From: Sue Howell <Sue.Howell@arun.gov.uk>
Sent: 03 February 2022 14:03
To: Planning.Responses <Planning.Responses@arun.gov.uk>
Cc: David Easton <David.Easton@arun.gov.uk>
Subject: Planning Consultation on: A/256/21/RES

Application ref: A/256/21/RES

Description: Approval of reserved matters following outline consent A/40/18/OUT for the erection of 525 No residential dwellings with associated parking, landscape, play areas & public open space.

Location: Land North of Water Lane Angmering

File location:
P:\875 - Water Lane\Drawings\HBA\Current Drawings

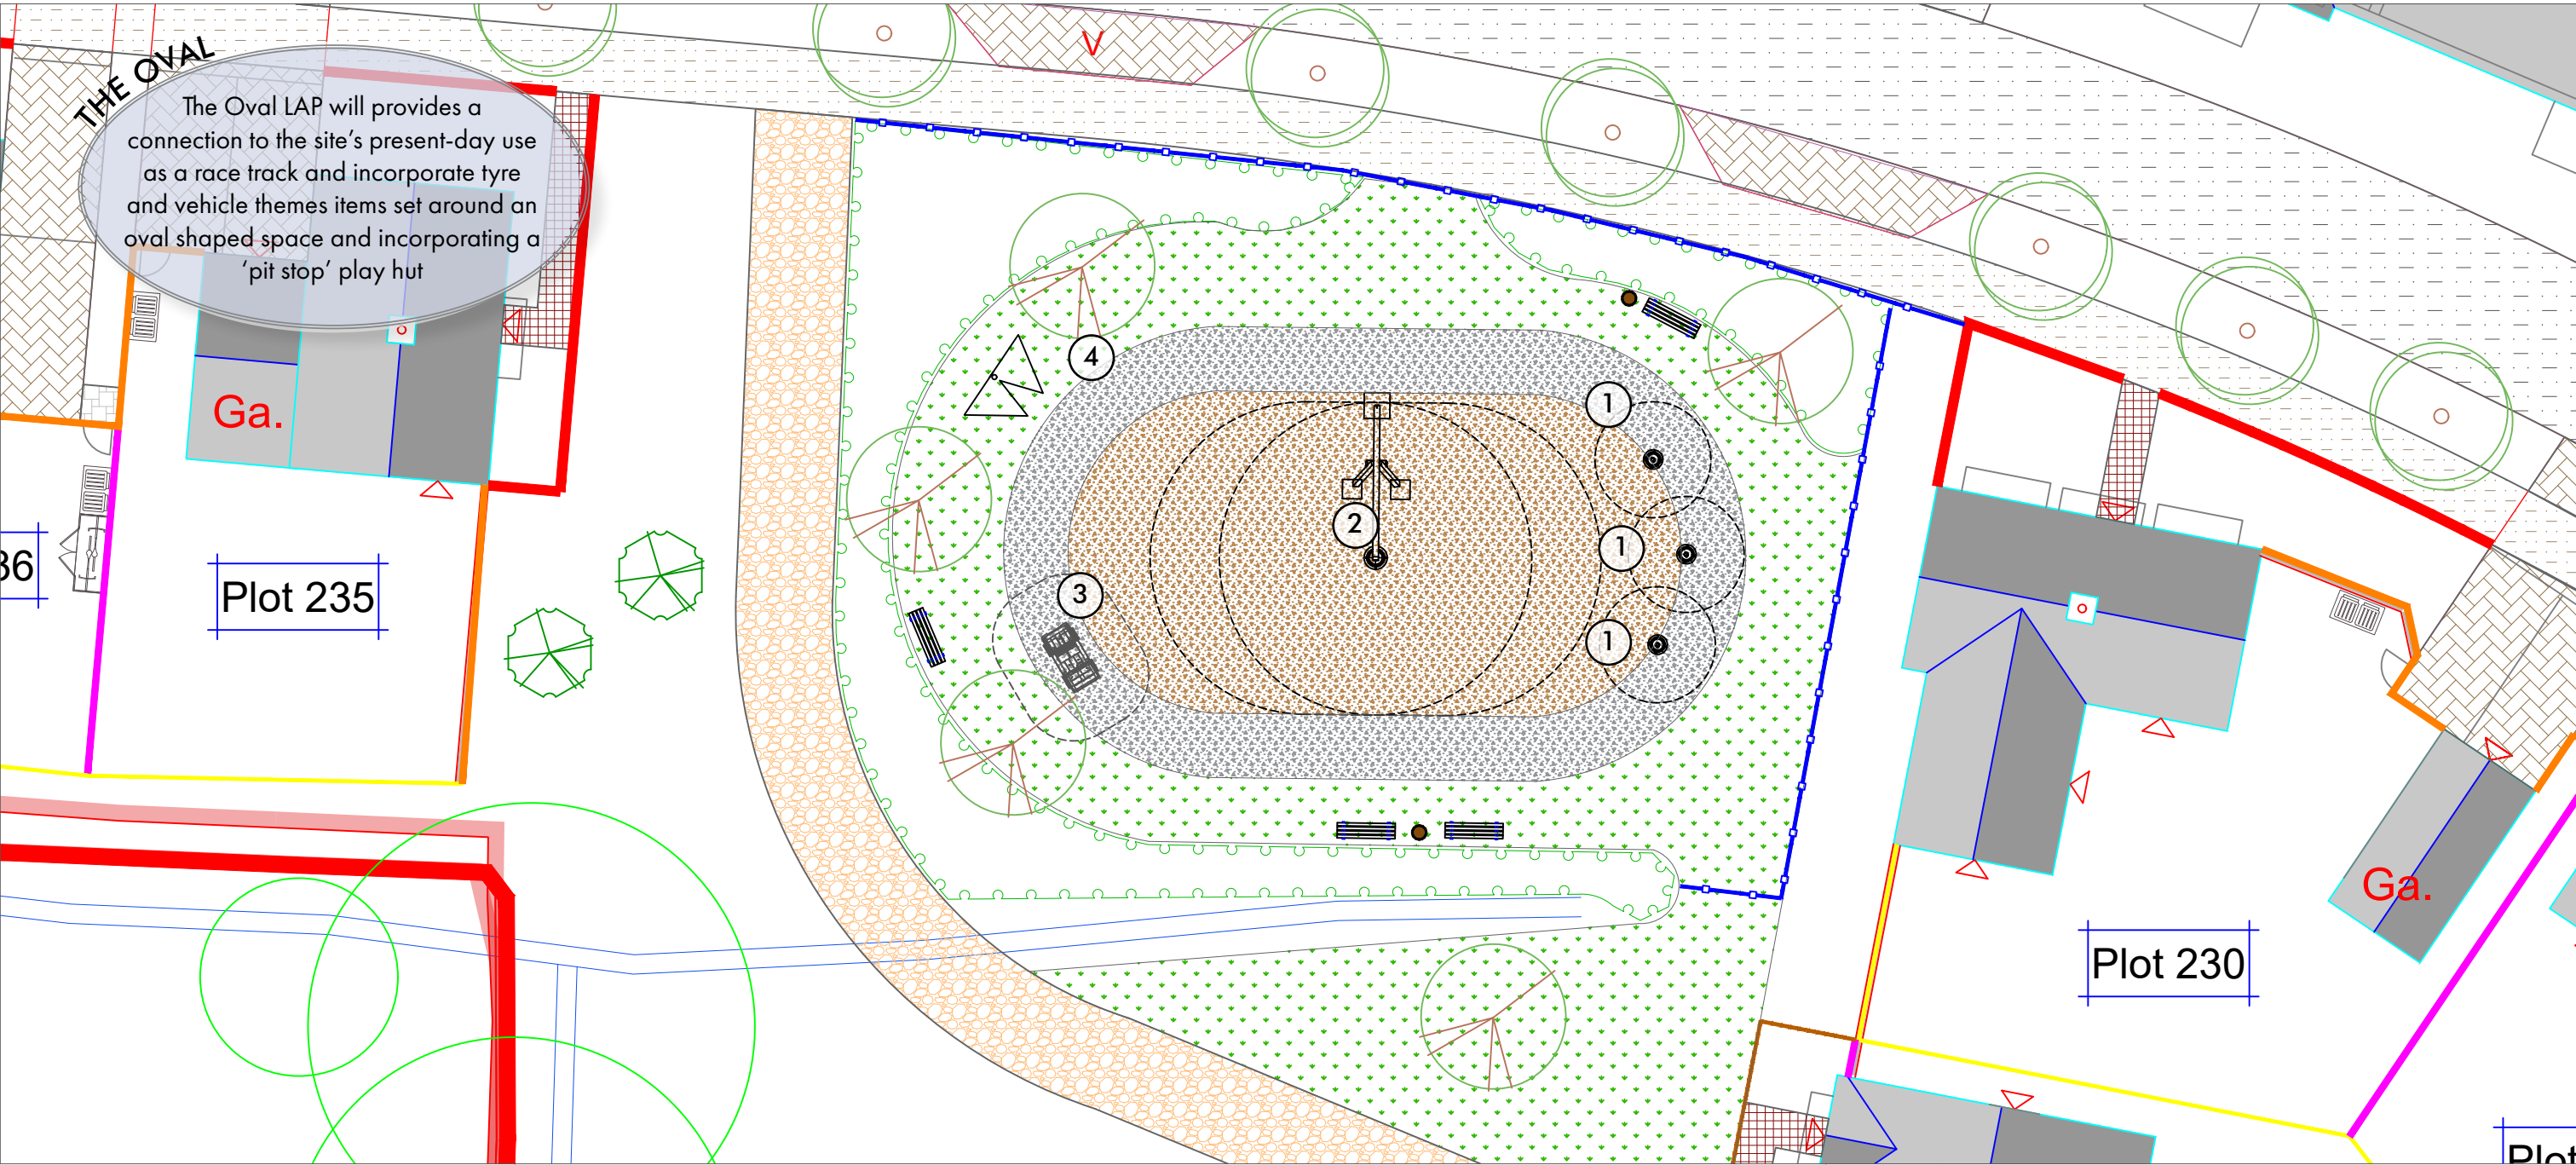
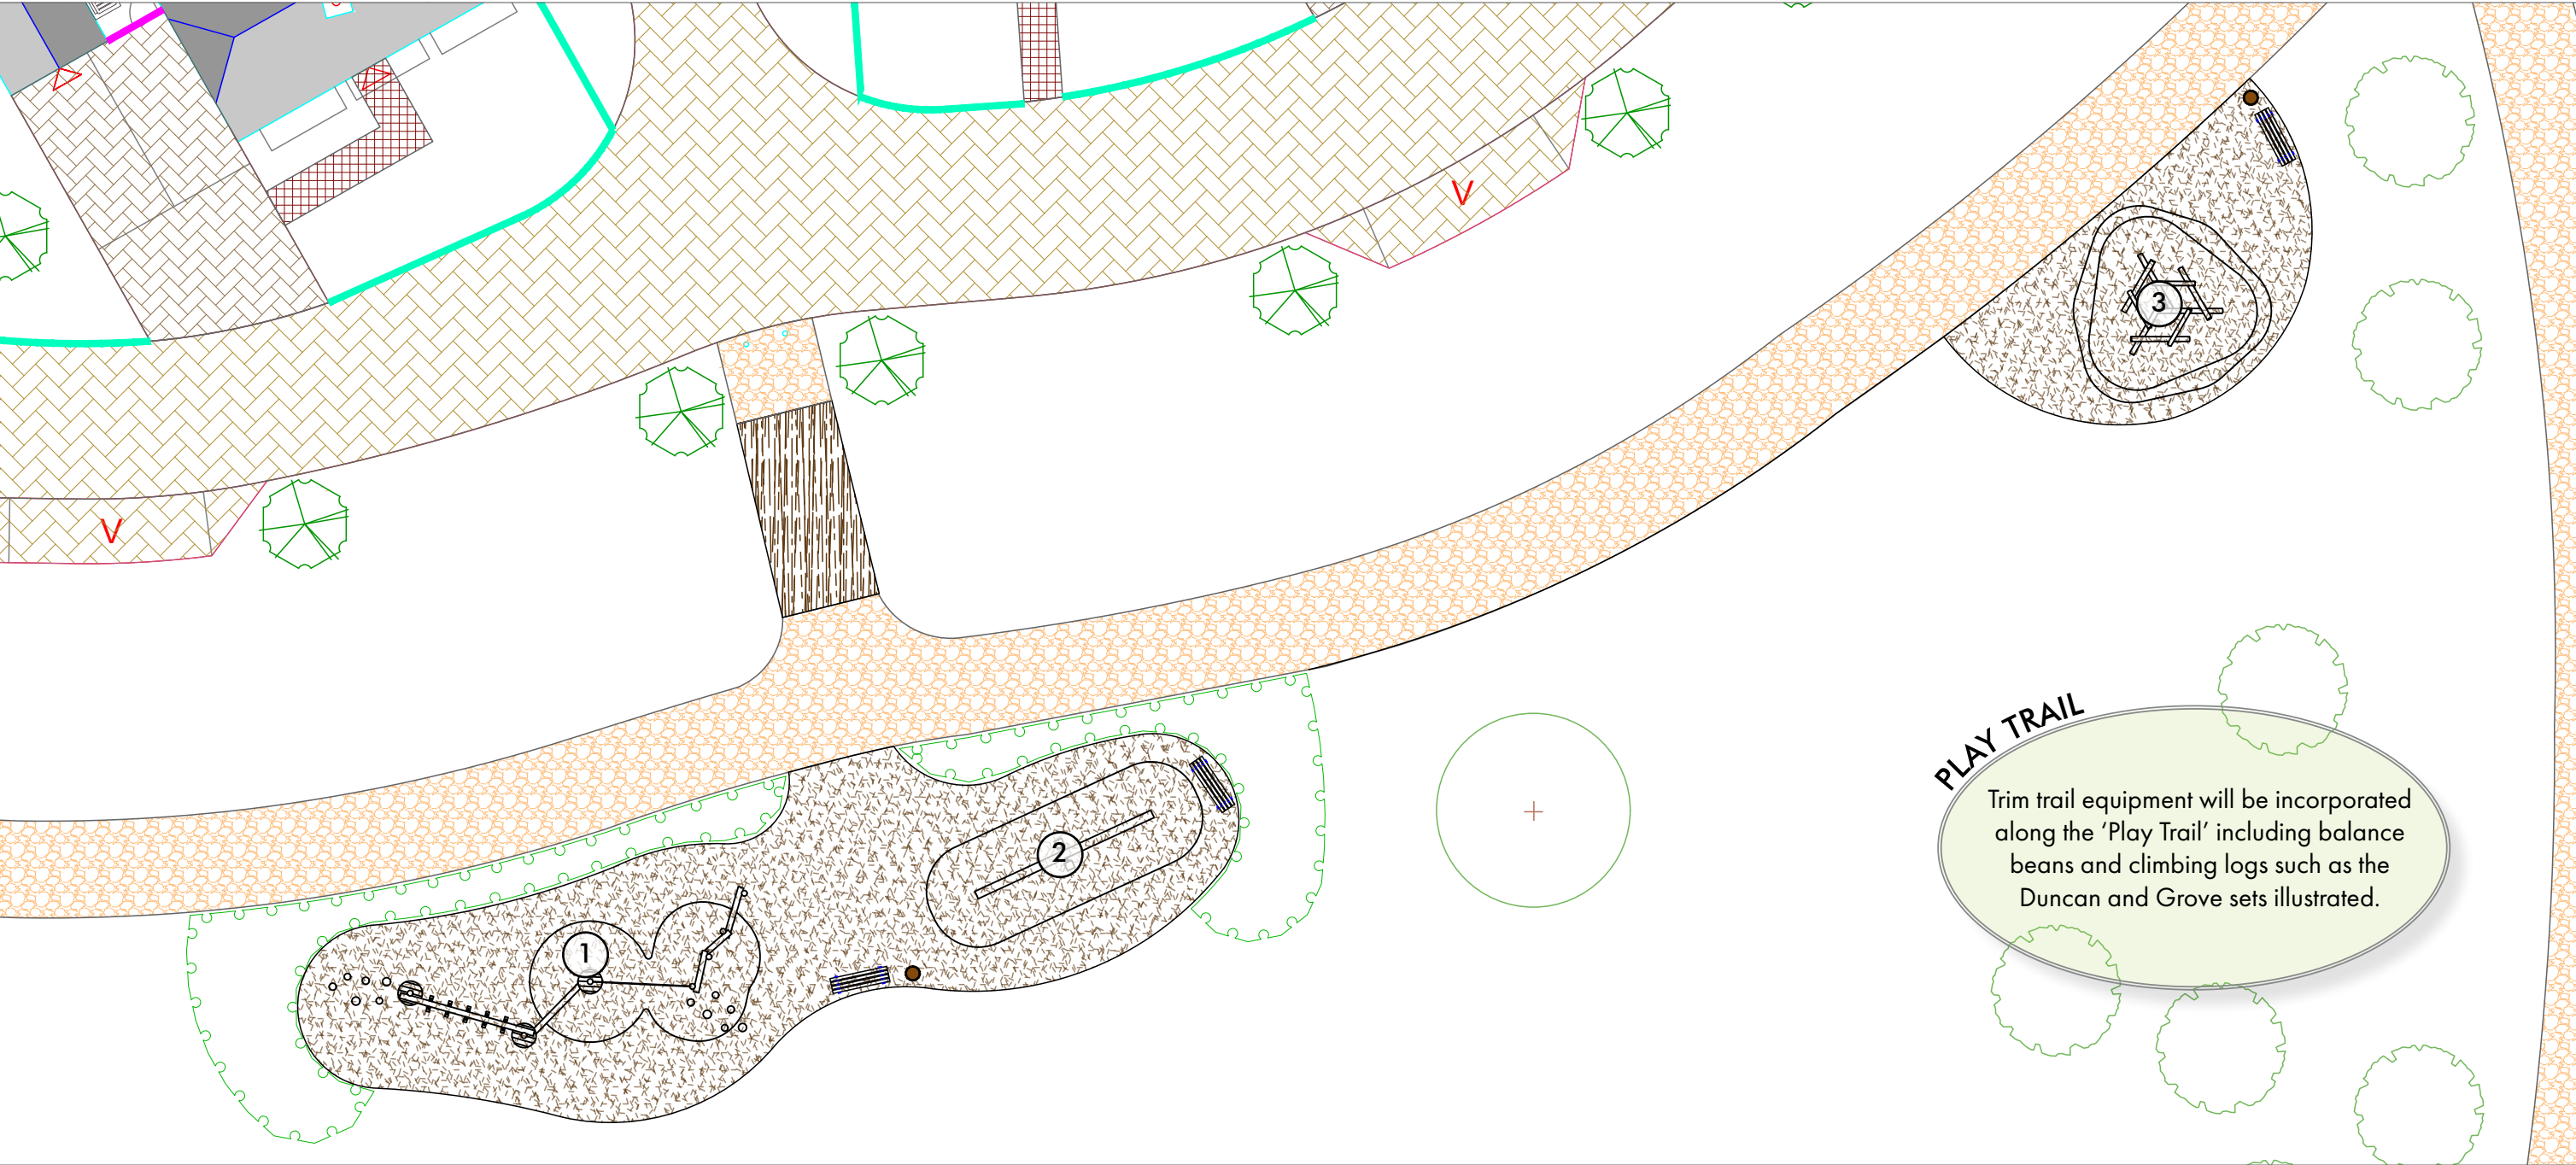
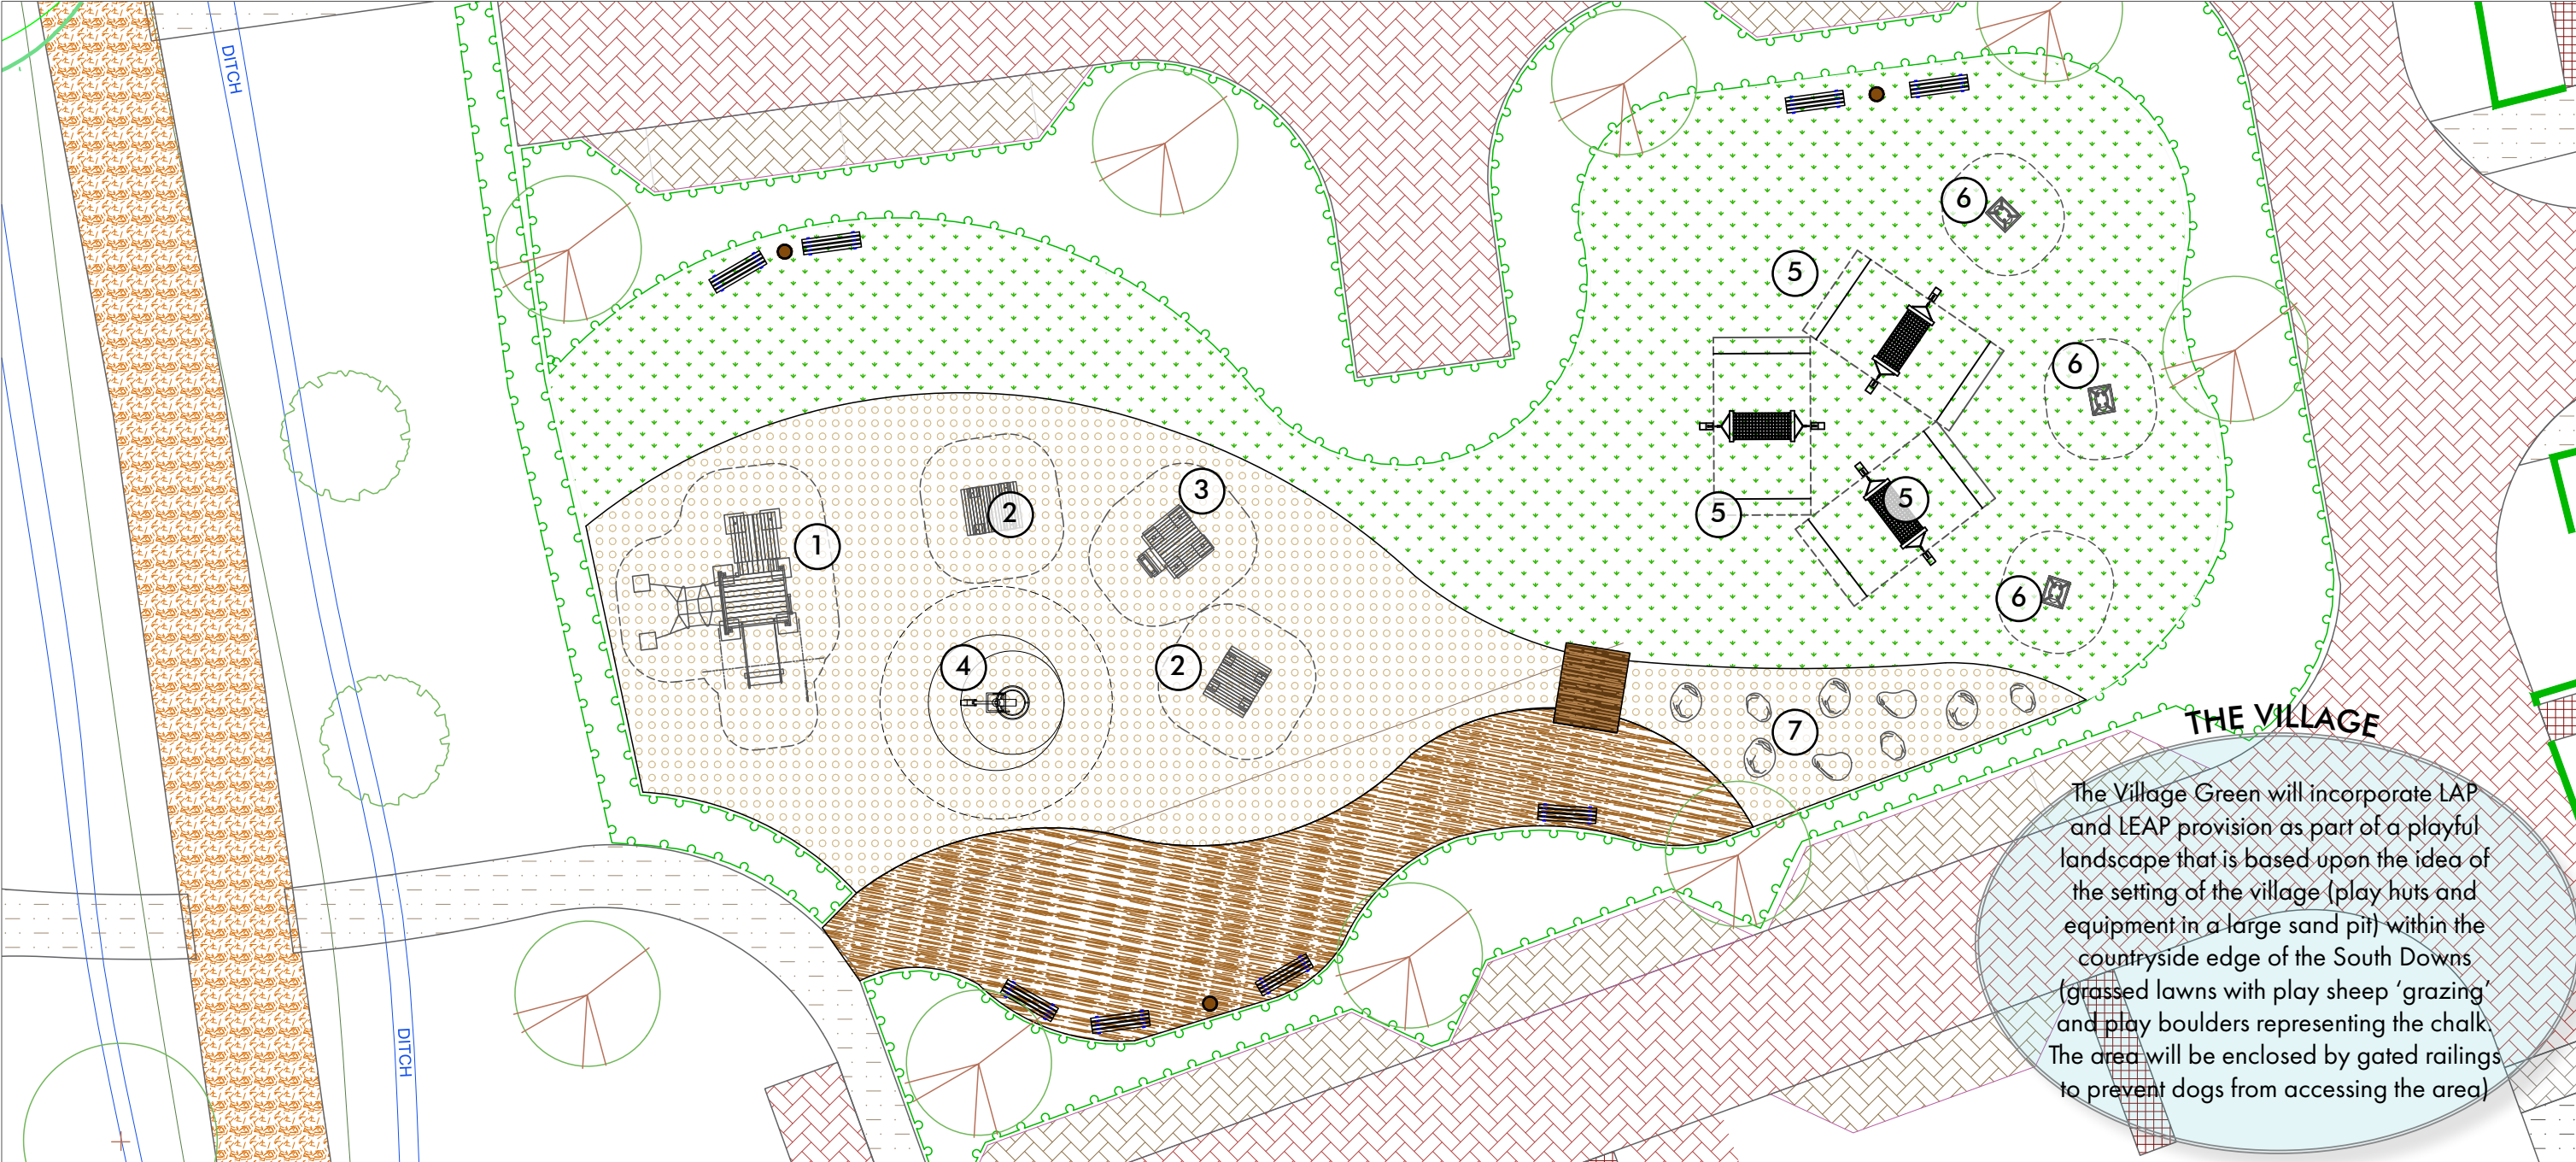
- The indicated Play including LAPs, LEAP, Sports and Fitness trail need further detail to be submitted re specification and equipment choice and accessibility of these. These need to demonstrate inclusive play, be challenging and material choice fitting for the location. Detail re general site furniture ie seating, litter bins, cycle stands etc to be submitted and approved.
